From:
Sent: Thursday, 18 April 2024 11:57 AM
To: Michael Doyle
Cc:
Subject: RE: Referral to Compliance - Mod app MP 10_0194 MOD 14 for Stage 1 Bulk Earthworks at Kings Forest

Subject modification application MP 10_0194 MOD 14

Figure 4 Typical Sections Plan Borrow Area

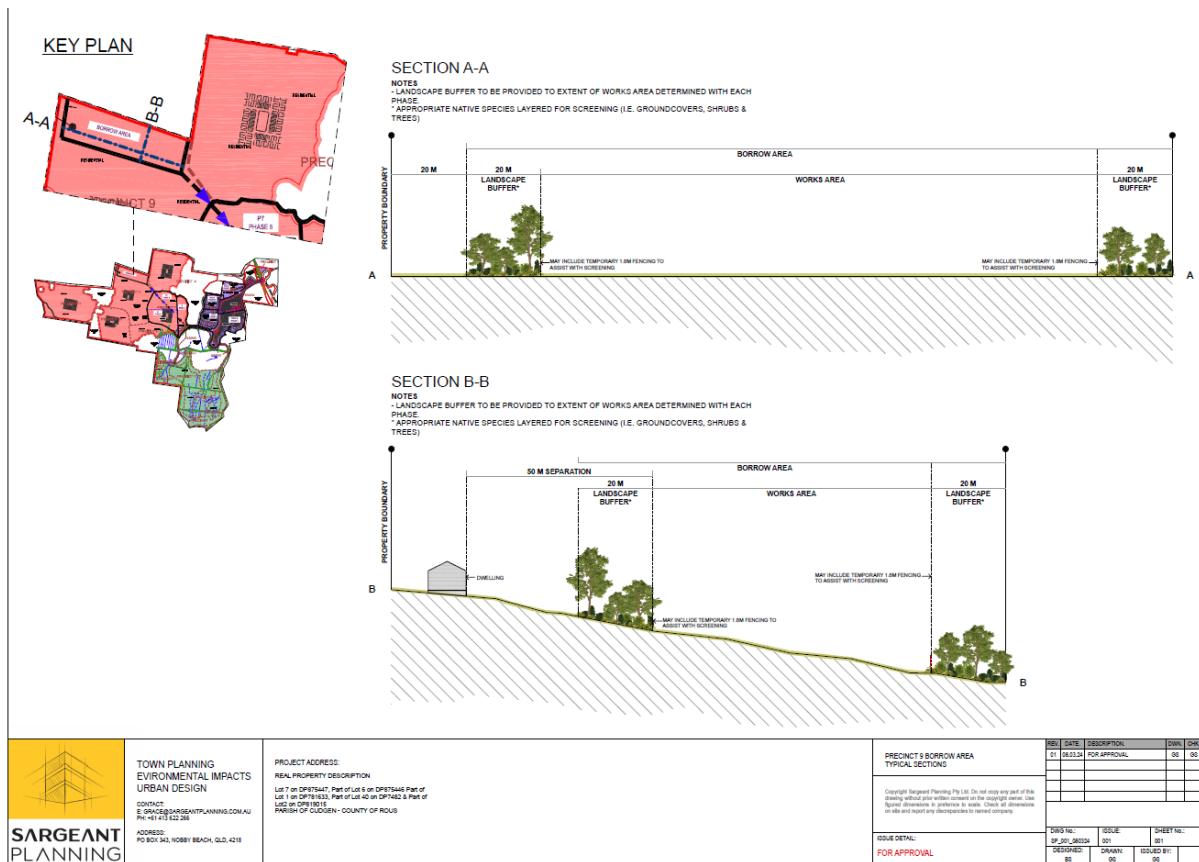
6	Whether 1.8m high is adequate for temporary screening (condition 10(k)).	<p>a) The timing of growth of the screening will need to be considered as well as the maturity of planted species. Compliance sees little value in planting a screen if it won't mature in time to shield the</p>

<p>activity and therefore provide the intended benefit to nearby residences.</p> <p>b) Line-of -sight from elevated positions would need to be considered and 1.8m may not be appropriate for certain angles of the site if comment 6a is not considered.</p> <p>c) The Proposal is not clear on what happens to the borrow pit at end of life. Will it get filled in, will it remain as an open excavation?</p> <p>d) Compliance cannot determine what is a suitable height for a fence but would suggest any fencing around the perimeter of a deep excavation would need to meet Work Health and Safety requirements.</p>
7	Geotechnical and constructability considerations that make the proposal appropriate or inappropriate.	<p>a) Compliance has no concerns with this proposal but suggests wording along the lines of a "suitably qualified geotechnical expert".</p>
8	Any other matter based on details of the proposal, the history of the site or other relevant information.	<p>a. Leda and Shadforths were issued with Warning Letters (ENF 53846721 and 53846724) on 25 January 2023 for failing to comply with Part One, Condition 9(d) and Condition 52(2) of MP08_0194, essentially exceeding exposed disturbed areas. The Proposal does not mention this, only that no "infringement notices" have been issued.</p> <p>b. Compliance had to push Leda and Shadforths to manage exposed disturbed areas following commencement of construction. Initially there was limited proactive work to stabilise exposed disturbed areas or to investigate different methods to successfully move towards permanently vegetated. Rather Shadforths and Leda were encouraged to work on stabilisation by Compliance. Refer to MP08_0194-PA-51 and the Compliance's letter to Shadforths dated 22 February 2023. The letter was issued in response to Shadforths letter to Compliance dated 8 February 2022. It was the Warning Letter that required Shadforth to <i>"submit via the Major Projects Portal a detailed document, or set of documents, that explains the process of how the Project will comply with the maximum exposed disturbed area limits allowed by Part One, Condition 9 and Condition 52(2) of the Approval at any time in undertaking approved bulk earthworks"</i>. In response Shadforth submitted a 109 page document outlining their methods for managing exposed disturbed areas. It is considered unlikely that this would have been prepared if not for the Warning Letter.</p> <p>c. <i>Environmental Officer</i> - Compliance has an ongoing concern that the Environmental Officer provisioned under Condition 71 has had limited input into compliance as required by the condition. The role of the Environmental Officer appears to be that of conducting environmental monitoring required by the Approval and management plans and reporting of that monitoring rather than an oversight of all compliance matters associated with the Approval, specifically construction related activities - <i>"Their role shall be to oversee environmental compliance of the project until completion conditions have been satisfied"</i>.</p> <p>i. Compliance requests that either the Environmental Officer role be replaced with the more commonly used Environmental Representative requirement or the requirement of the Environmental Officer be reviewed and clarified.</p> <p>d. <i>Definitions</i> - Compliance request that key terms in this Modification be defined to provide clarity, including, but not limited to:</p>
